Application Ref:	3/2026/0457			 Ribble Valley Borough Council www.ribblevalley.gov.uk
Date Inspected:	29/07/2026	Site Notice:	29/07/2026	
Officer:	MC			
DELEGATED ITEM FILE REPORT:				APPROVAL

Development Description:	Proposed erection of additional cow cubicle
Site Address/Location:	Bolton Fold Farm Alston Lane Longridge Preston PR3 3BN

PROPOSED ELEVATIONS

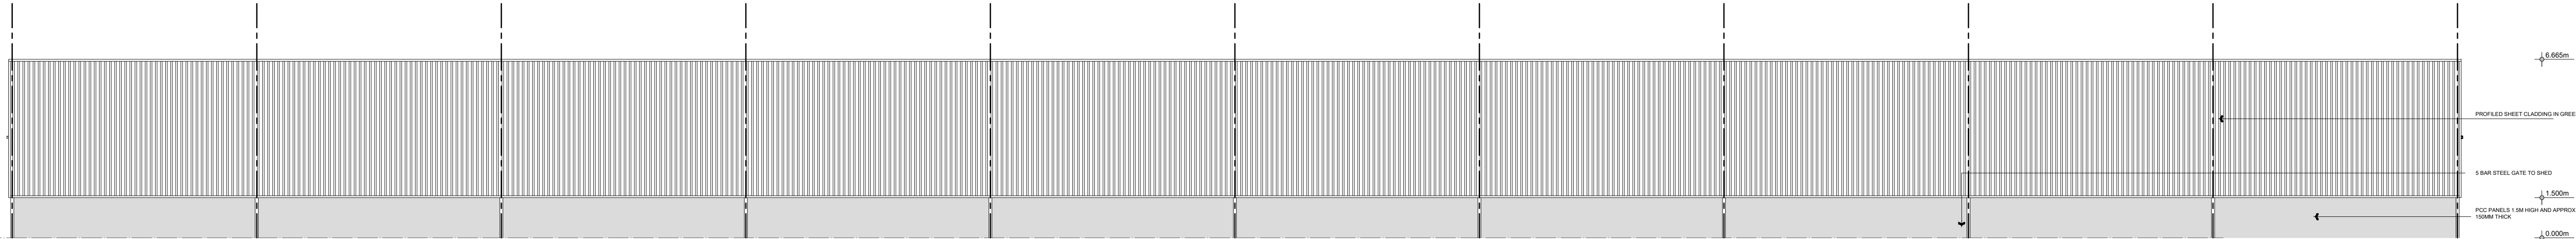
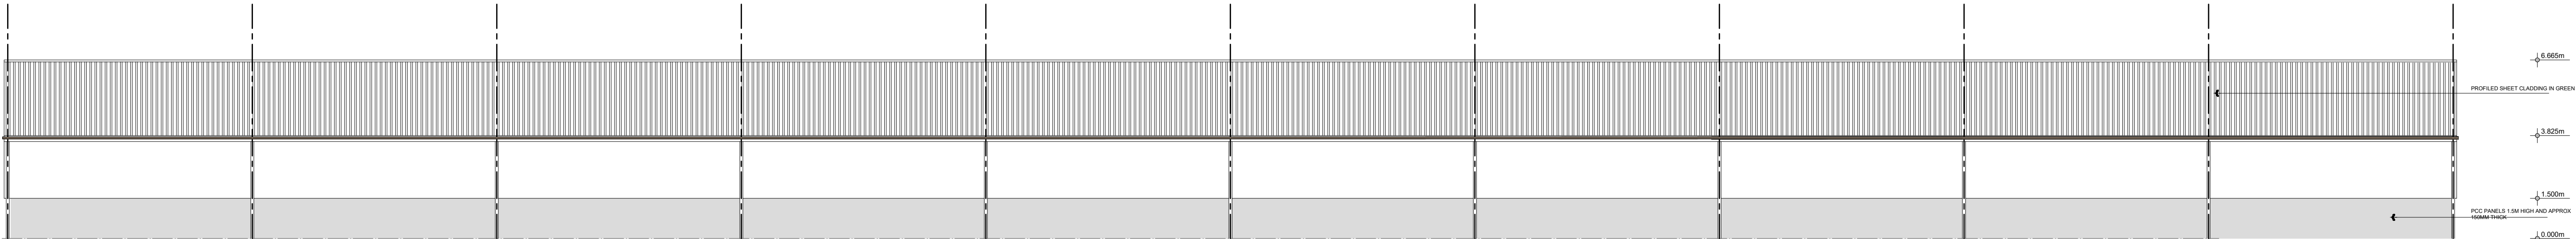
CONSULTATIONS:	Parish/Town Council
Longridge Town Council:	Request what type of cladding is proposed and RVBC should ensure the cladding meets the latest safety standards/regulations

The livestock building would have a length of approximately 91m, a depth of just over 10 and would have a mono-pitched roof with an eaves height of approximately 6.6m and an eaves height of approximately 4.2m, with an eaves overhang. The building would be constructed of concrete panels and York boarding to the walls, profiled sheet cladding to the roof.

The proposed agricultural building would be sited approximately 63m to the east of the existing farmstead. The siting of the building is constrained due to the presence of the existing gas pipeline and therefore the siting cannot be located immediately to the north and east of existing buildings. Whilst the proposed development would result in some urbanising impact and encroachment within the open countryside, the building has been justified with regards to the agricultural need and it would not be reasonable to site the building elsewhere within the farmstead due to the presence of the gas pipeline. The Council are satisfied that the proposed building and associated hardstanding would be an acceptable size, scale and design with a height of 6.6m and an eaves height of 3.8m, remaining open fronted to the front elevation.

PROPOSED SITE PLAN

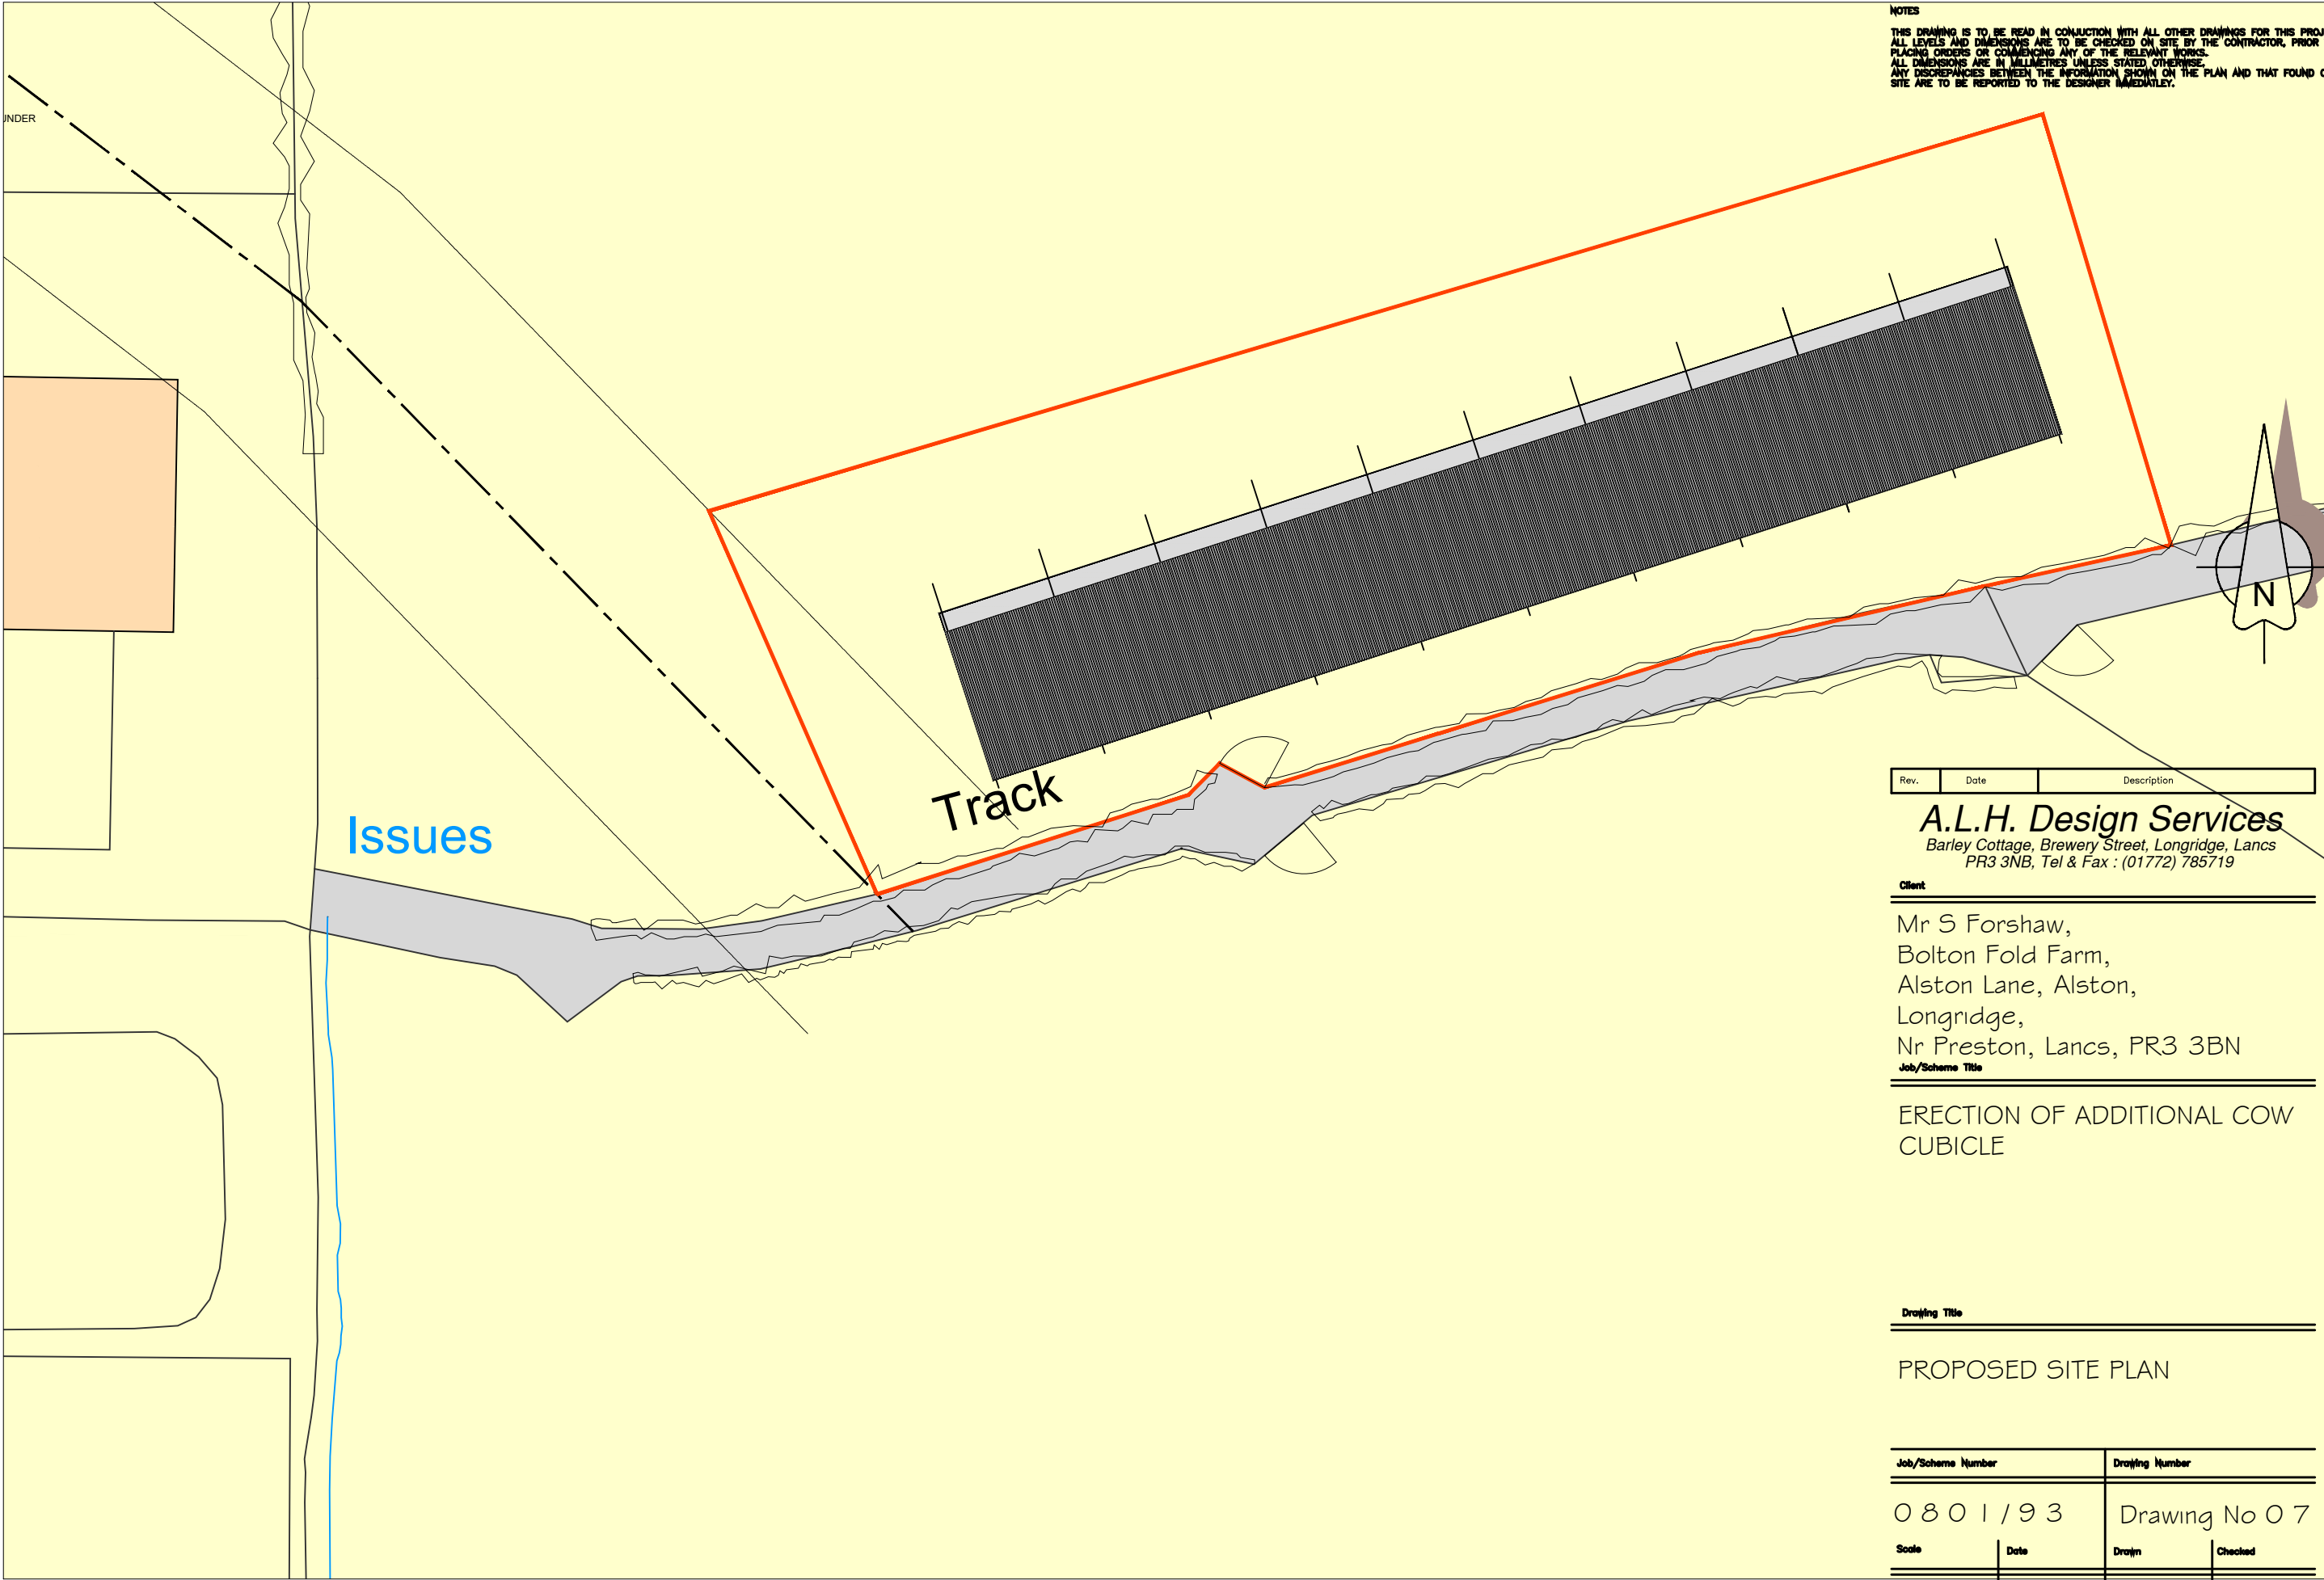
It should be noted that the submitted BNG plan shows an area of hardstanding which was not originally provided on the proposed site plan. This has now been updated accordingly. Prior to determination, the red line boundary has also been slightly updated to correct an error relating to Biodiversity Net Gain planting.

It is noted the application site lies within a consultation zone for a Major Gas Pipelines. The proposed hardstanding does appear to be within the outer buffer zone however on further consultation, HSE have identified that they Do Not Advise Against the granting of planning permission.

Proposals Plan

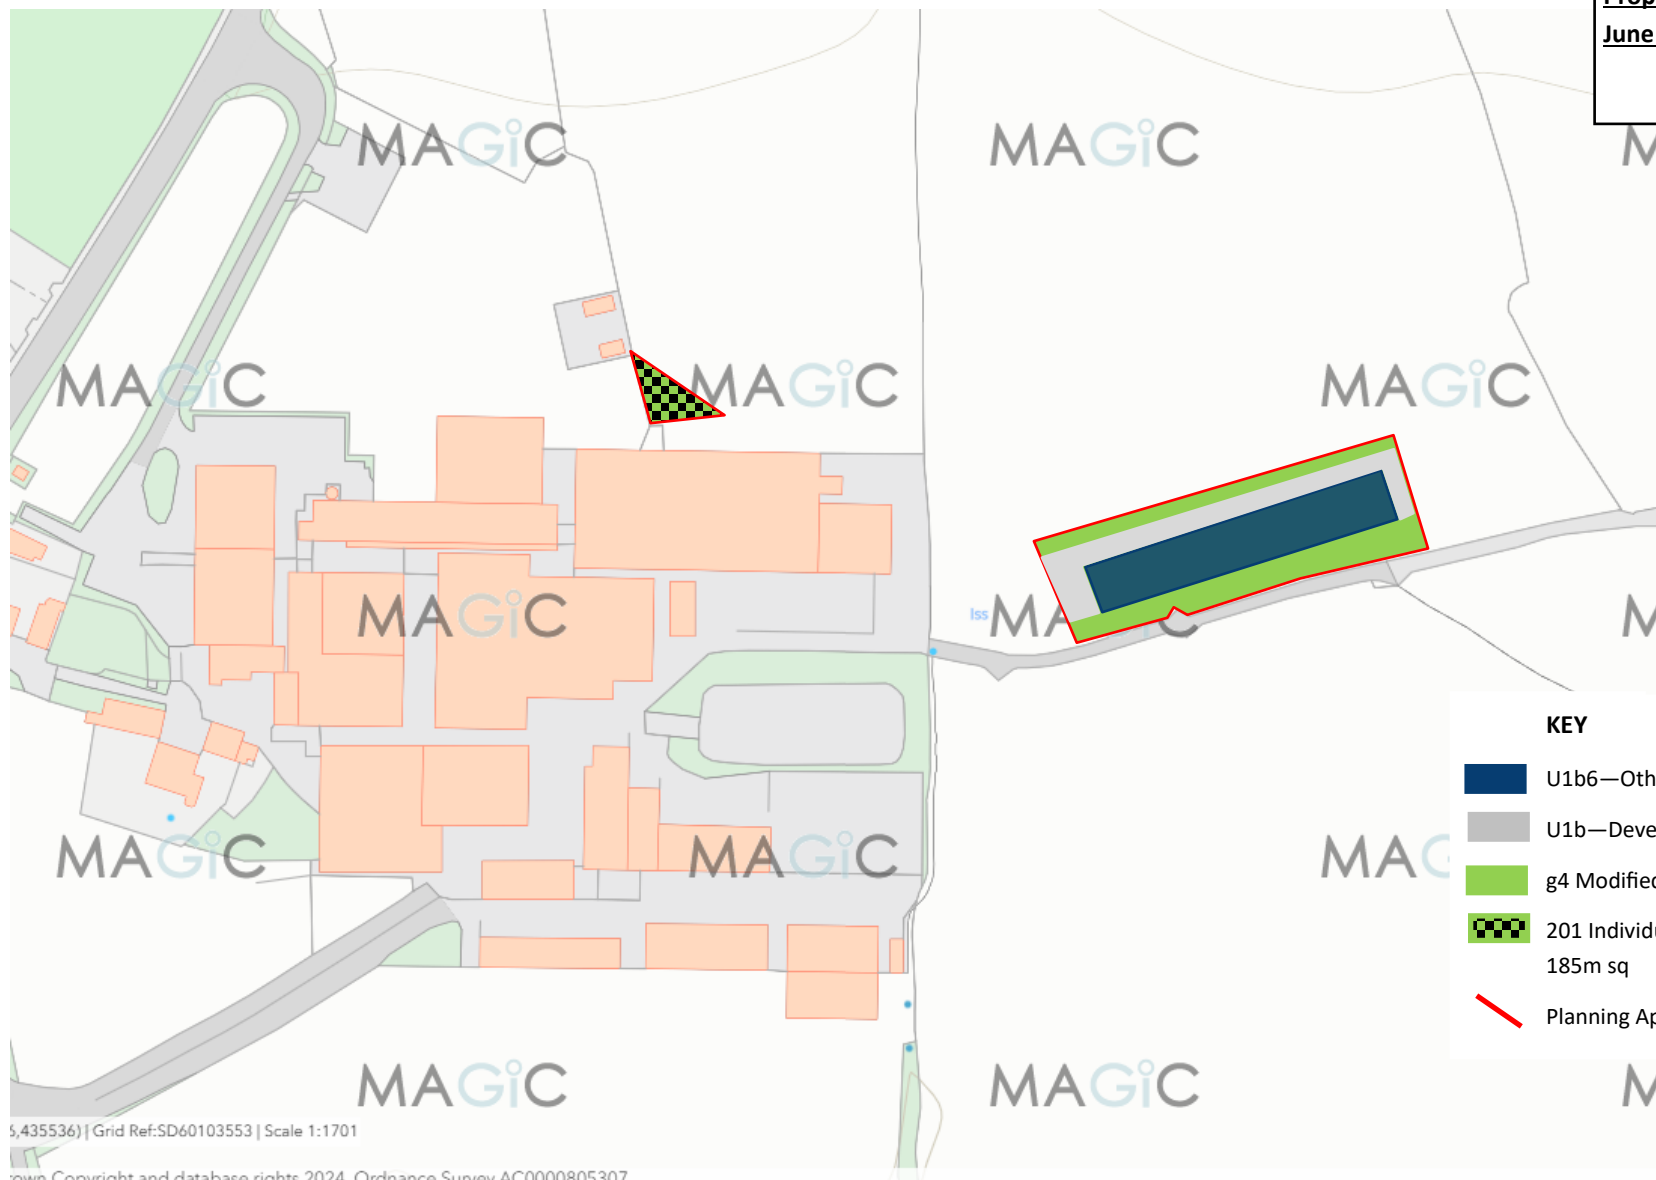
With regards to Biodiversity Net-Gain (BNG), the proposed development would result in the loss of 0.11 units of on-site habitat. In order to meet the 10% minimum requirement for BNG, the proposal includes the planting of 10 rural trees and a total of 0.1456ha of modified grassland to provide a net-gain of approximately 11.29% which would be acceptable.
